23 May 2024

Enquiries: Brett Maynard
Project No: 300304168

**RE: Calala Battery Energy Storage System
Response to Submissions and Request for Further Information**

Concept plan

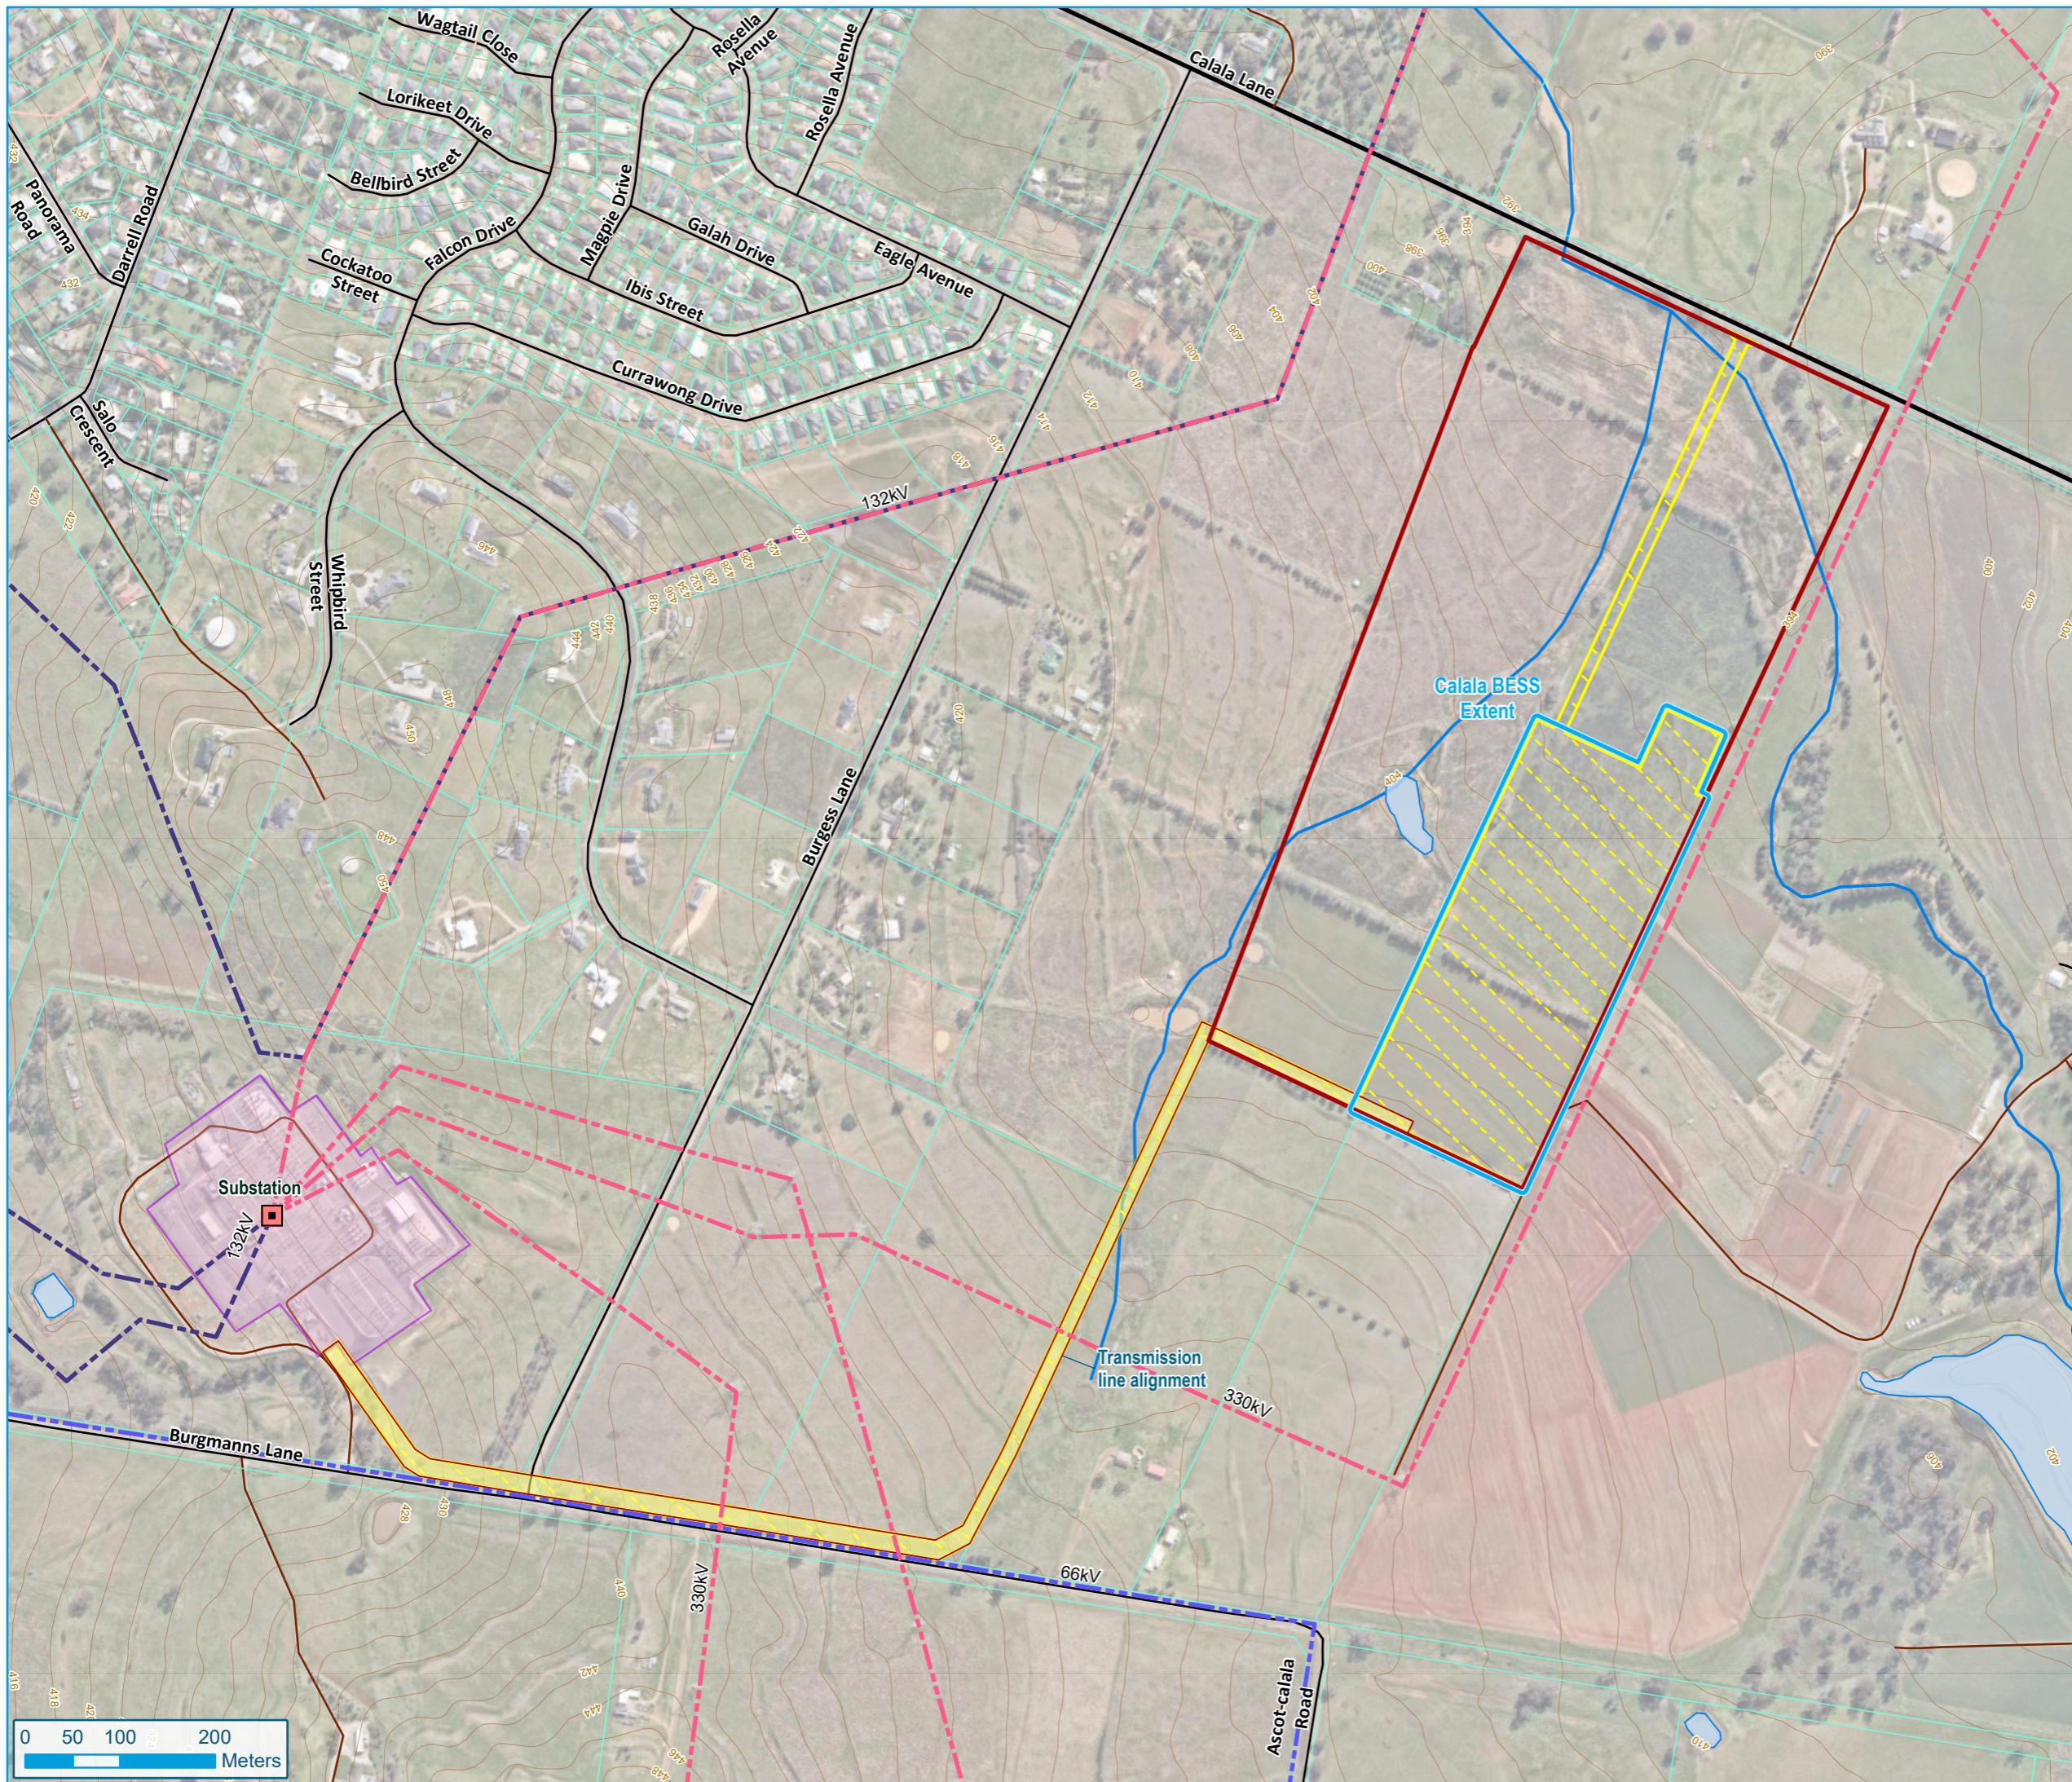
As it relates to transport, the primary change to the proposal involves the relocation of the vehicular site access around 15 metres to the east, as well as the internal road network layout. Internal roads and on-site car parking will be designed in accordance with the relevant Work Specification, Industry Standards, Safety in Design (SID) and the Australian Standards to the extent they are relevant to the nature of the project.

As documented in the Transport Assessment, the recommended Safe Intersection Sight Distance (Austroads, 2023) at an unsignalised intersection based on a driver reaction time of 2.0 seconds is 248 metres and the AS2890.2 desirable and minimum sight distances for a typical driveway along Calala Lane are 139 metres and 222 metres, respectively. The revised site access driveway is in a good location with respect to road safety, with Calala Lane sight lines in both directions that continue to exceed all relevant Austroads and Australian Standards requirements. As such, the revised site access arrangements are considered suitable as part of the proposed development.
